AMENDMENT REPORT 2

Jindera Solar Farm

June 2020

Project Number: 17-323

Dwg No: J2104-100 Rev: P9

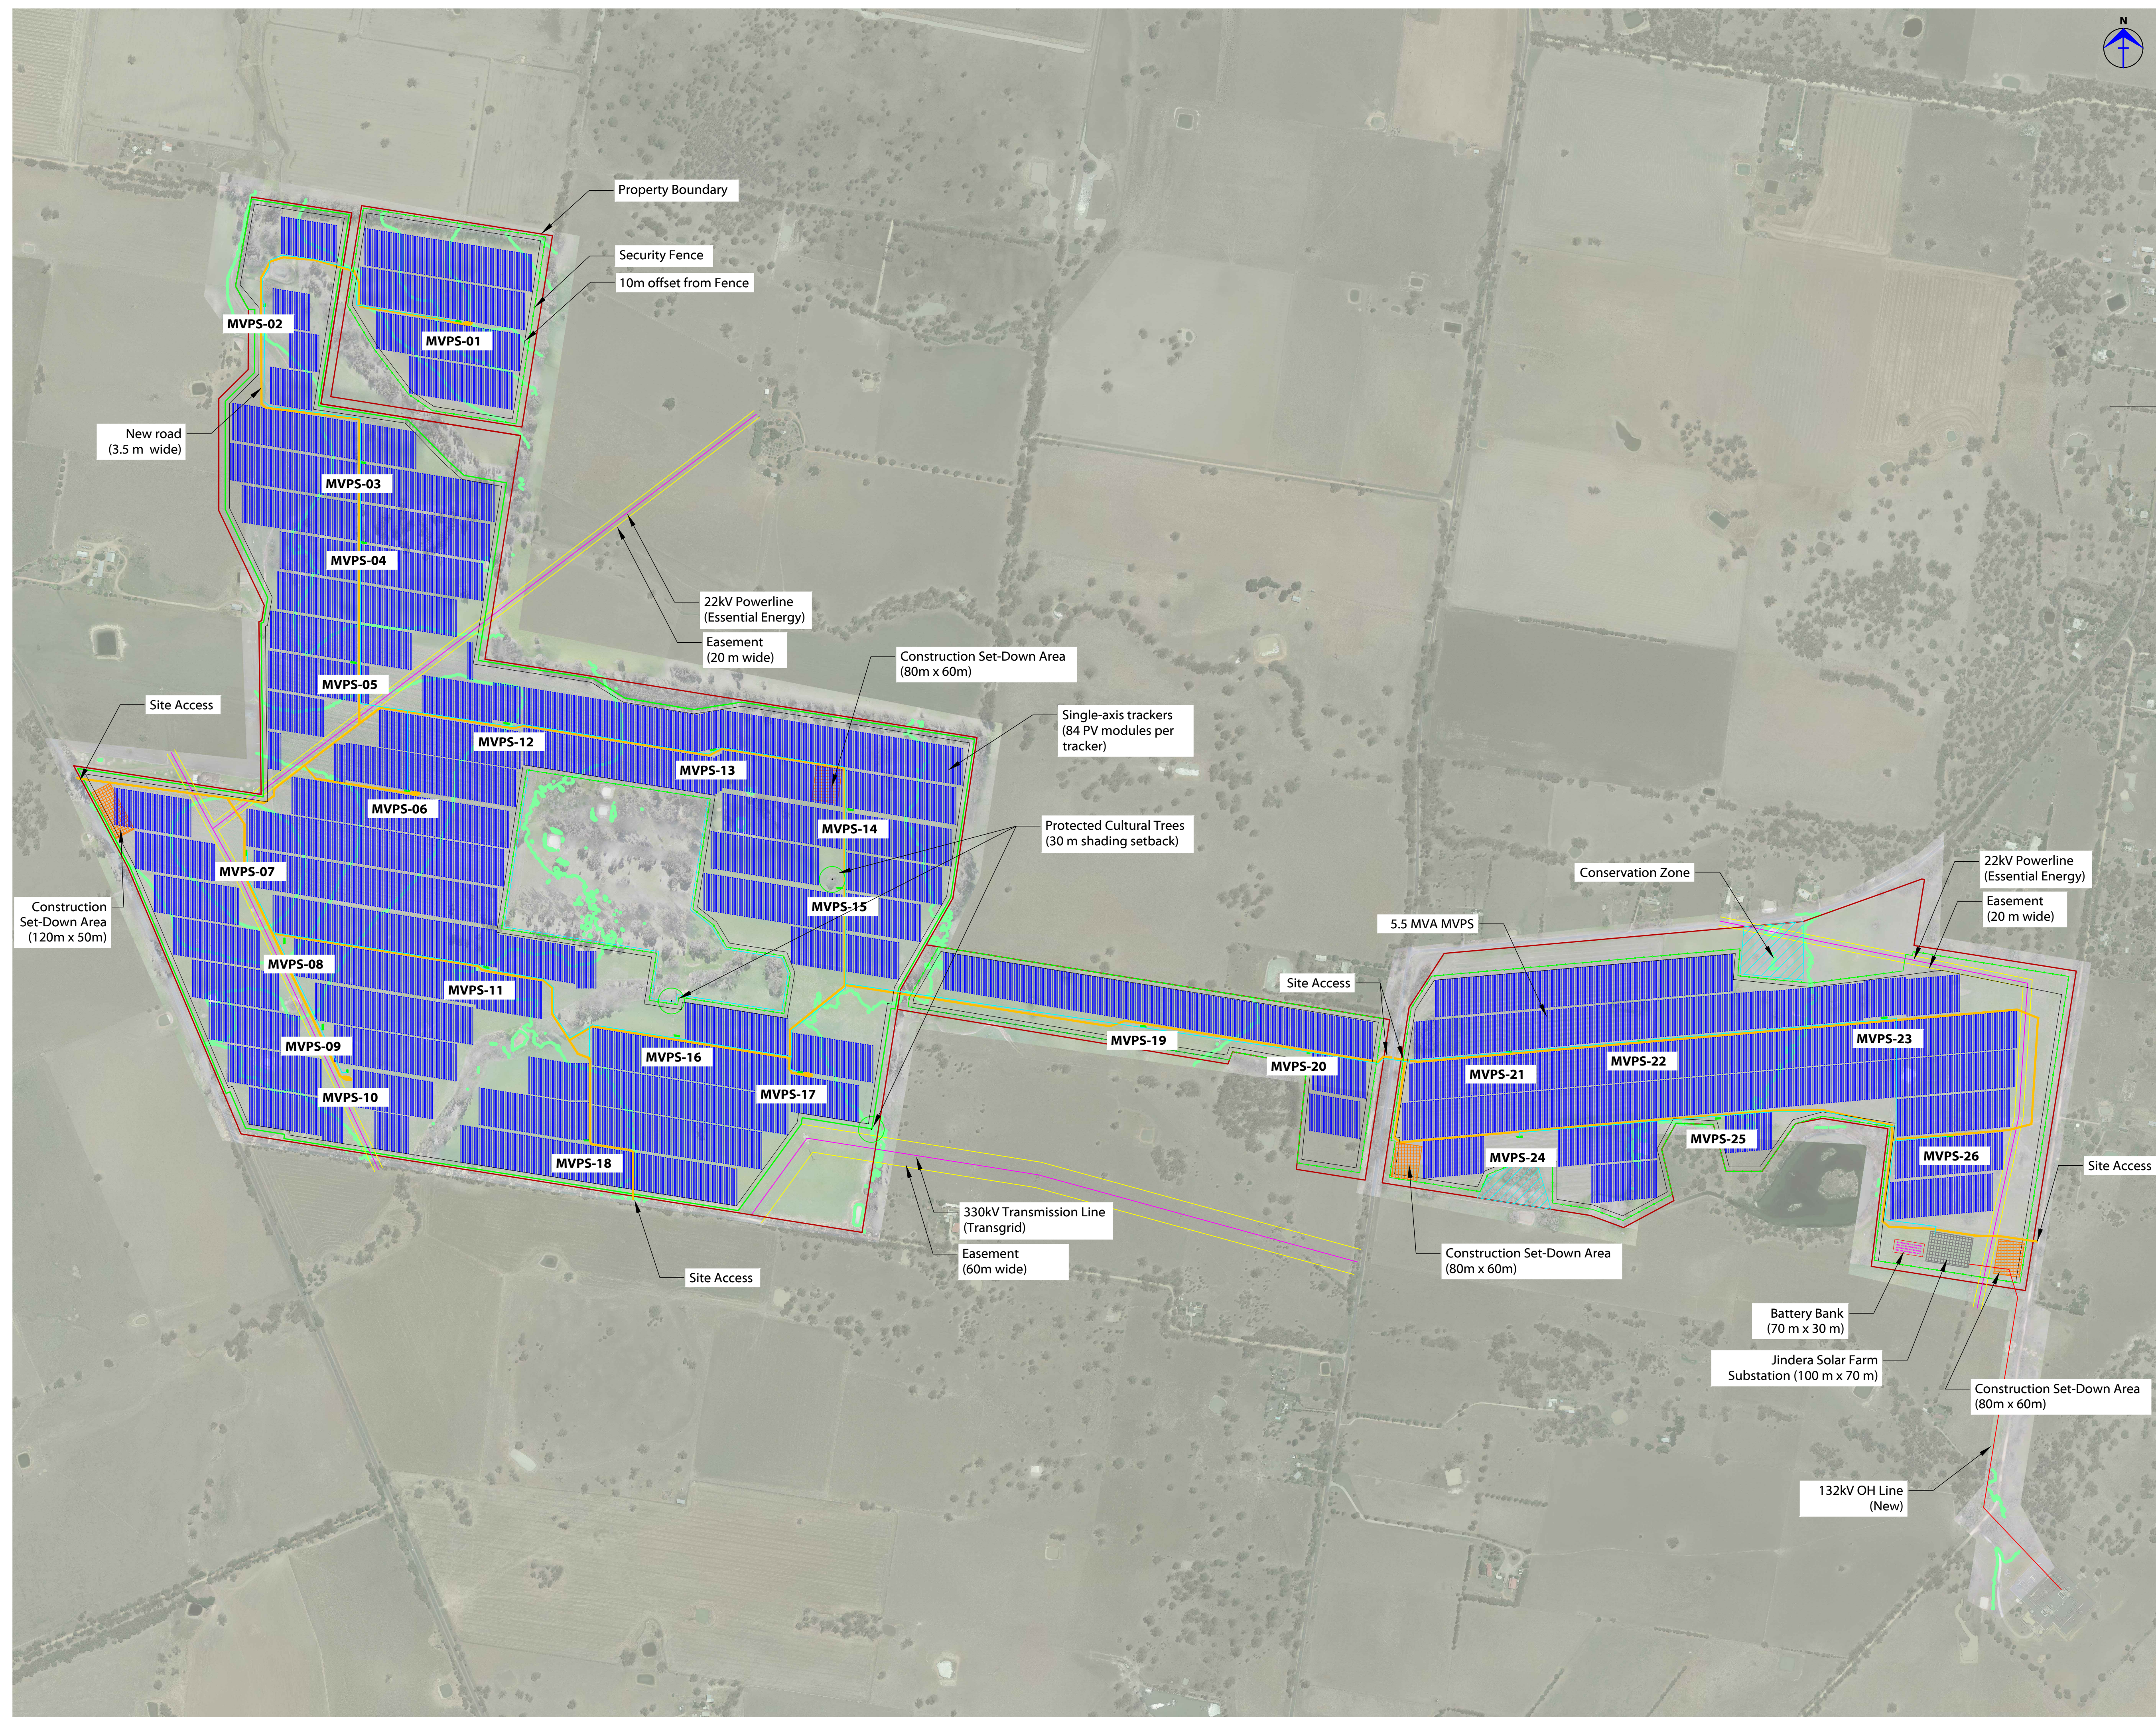
The development footprint has been refined to avoid three patches of PCT 277 within Lot 155 DP753342, as well as retaining additional vegetation overhanging Lot 138 PCT 753342 (Figure 2-1). This has resulted in a reduced clearing of approximately 3.9 ha of PCT 277 and overall reduction of credit offset obligations (Section 4.1).

The development footprint has been refined within the vicinity of Kilnacraft Creek to provide better linkage between the vegetation along the creek line and the areas of PCT 277 that have been retained / protected within the site layout. The updated development footprint along the creek, retains all riparian vegetation, whilst allowing a minimum 30 m buffer from the creek bed as per the requirements of the *Guidelines for Controlled Activities on Waterfront Land (Natural Resources Access Regulator 2018)*.

The retained patches of PCT 277 (Figure 2-1) will be fenced by stock-proof fencing. Access gates will be added to allow access on the newly formed road that intersects two patches of vegetation. The length of Kilnacroft Creek will also be fenced with stock-proof fencing, with access gates to allow access on existing proposed internal roads.

As a result of the relocation of fences, two farm dams will also be retained and protected.
